# CITY OF ALBUQUERQUE

**RE:** UNM Starbucks and Freddie's  
Grading and Drainage Plan  
Engineer's Stamp Date 2-22-2017 (File: K16D075)

**RE:** UNM Starbucks and Freddie's  
Grading and Drainage Plan  
Engineer's Stamp Date 1-27-2017 (File: K17D075)

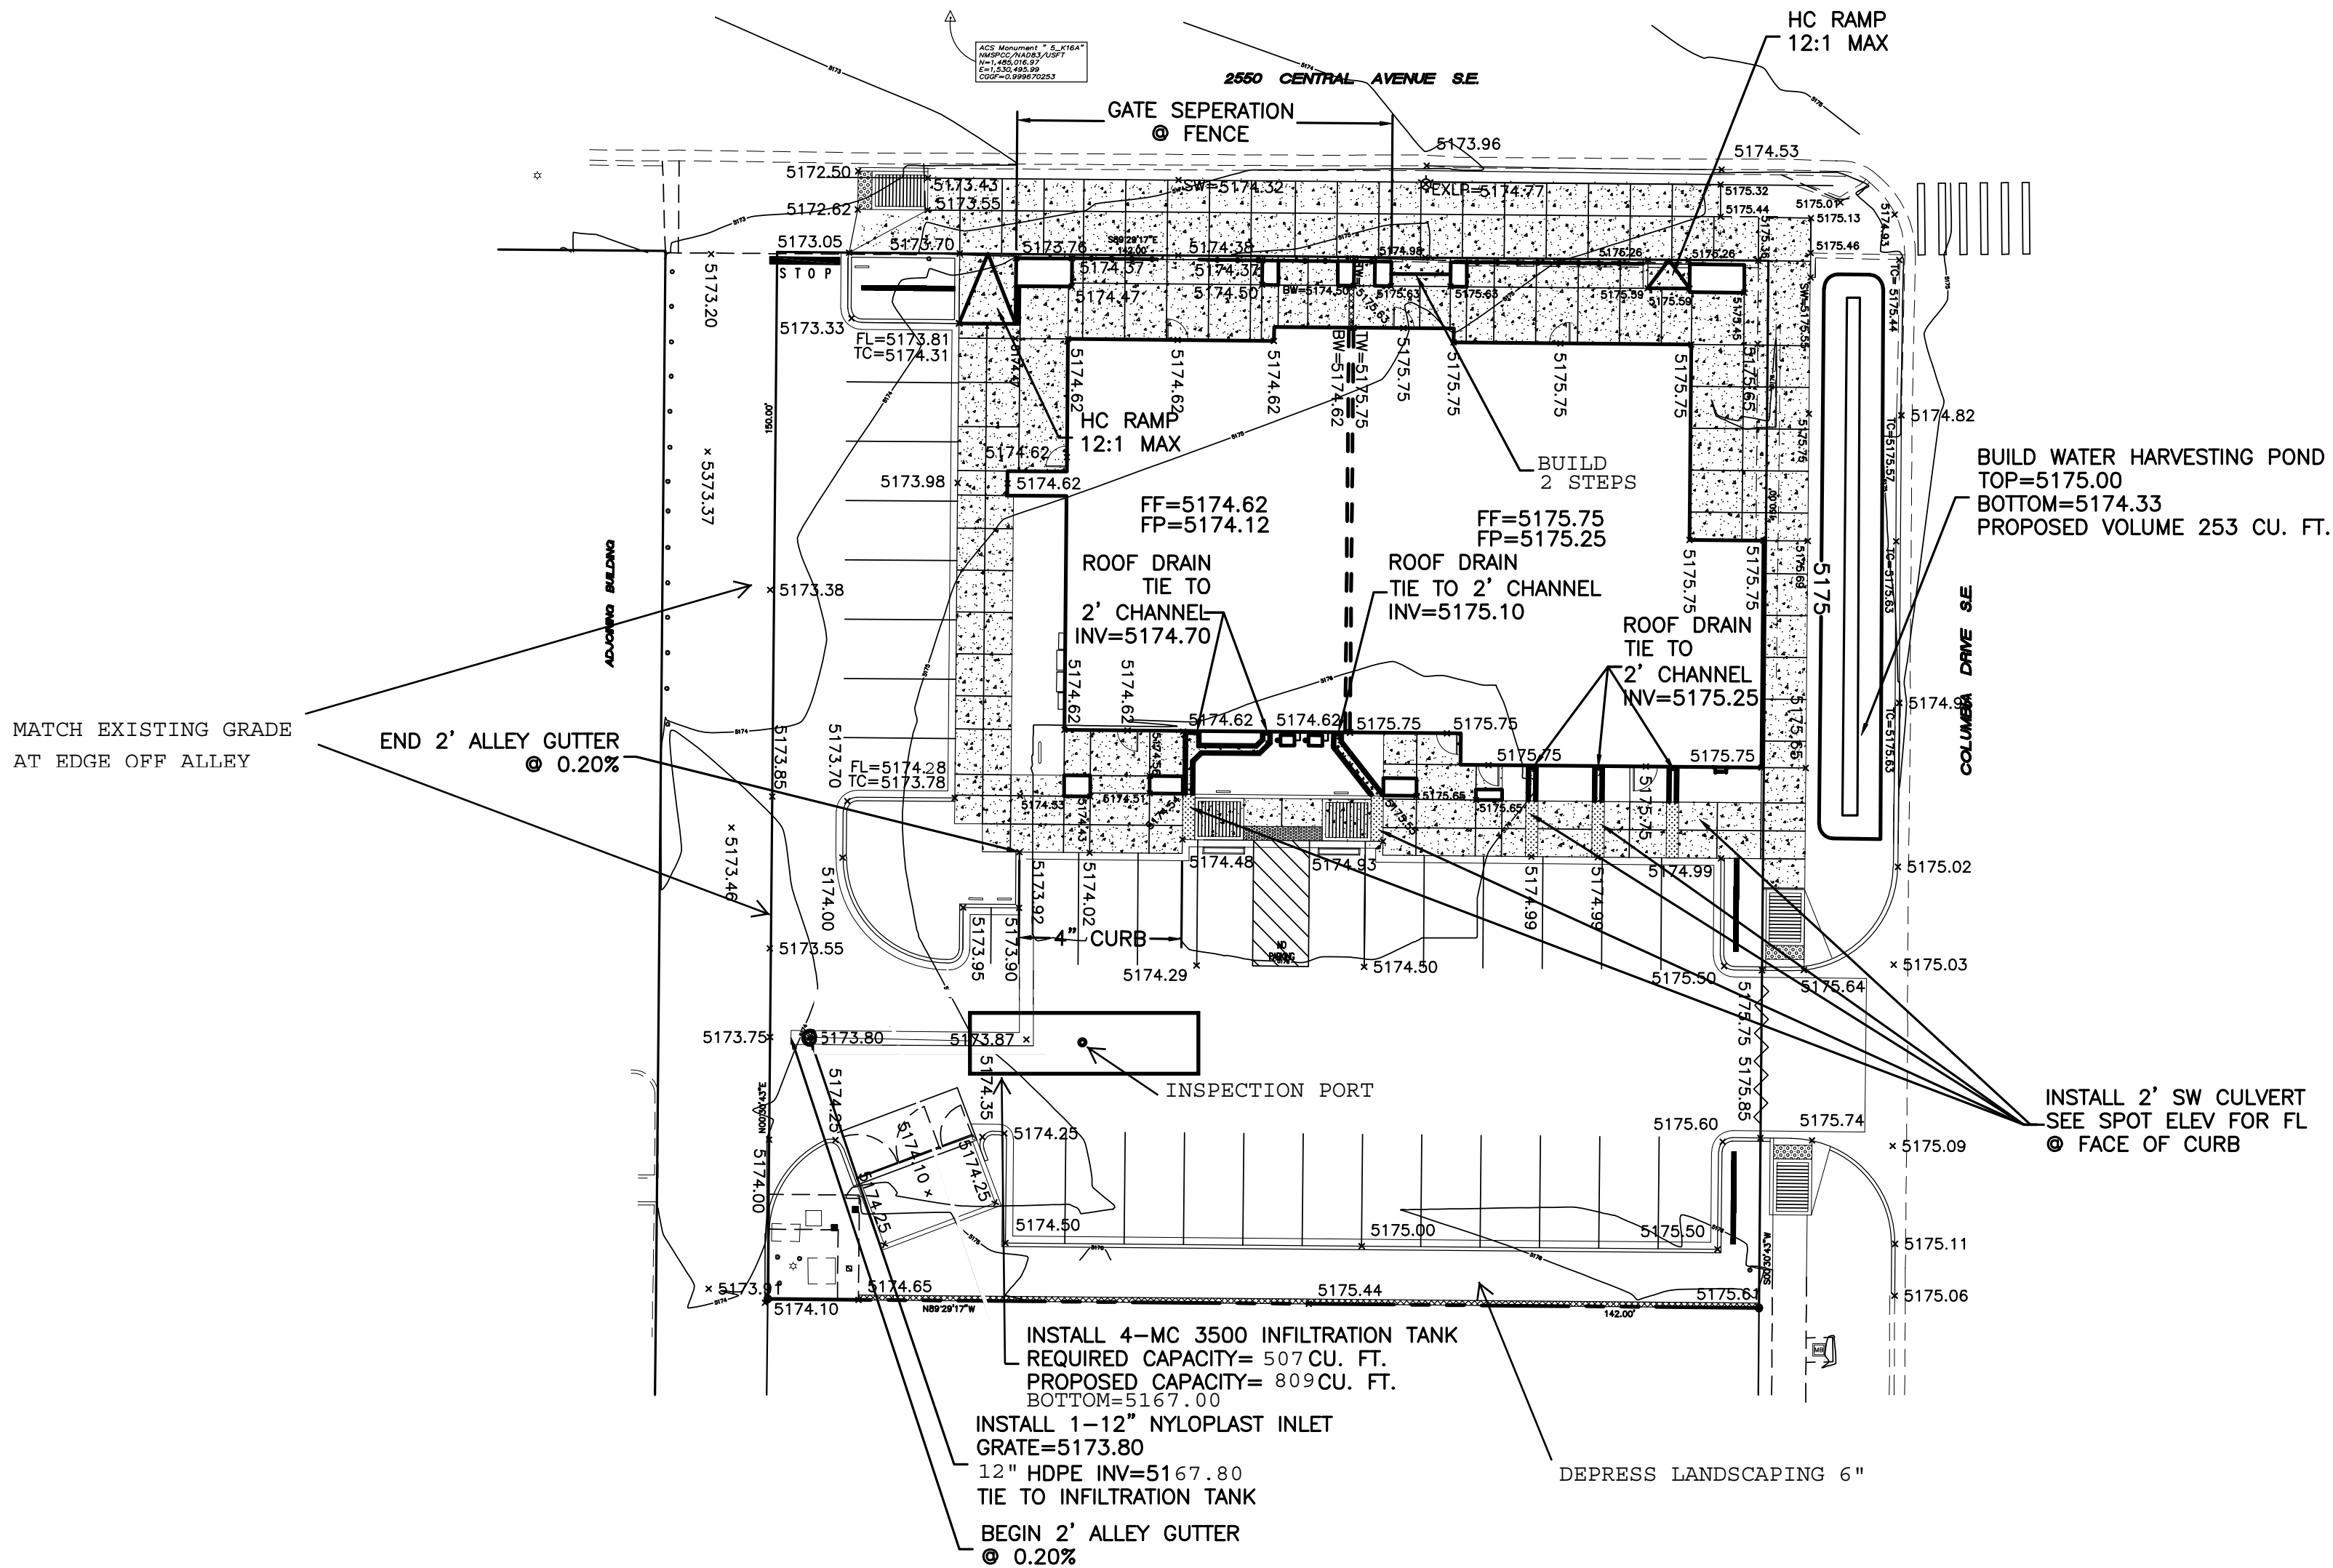
1. Provide build note and grade elevation for the dumpster.
2. Provide narrative for offsite flow.

THIS SITE IS A REDEVELOPMENT OF AN EXISTING SITE . THE EXISTING SITE DISCAHRGES 2.22 CFS TO A PUBLIC ALLEY. THE PROPOSED DEVELOPMENT GENERATES LESS THAN EXISTING FLOW RATES. THE FIRST FLUSH VOLUME WILL BE RETAINED BY THE PLACEMENT OF A INFILTRATOR SYSTEM AT THE OUTFALL FLOW LINE. THE SITE MATCHES THE EXISTING DRAINAGE PATTERNS. AND WILL TIE TO THE EXISTING ALLE NO UPLAND FLOWS IMPACT THE PROPERTY, DUE TO WATER CURB AND GUTTER AND WATER BLOCKS AT DRIVEWAYS
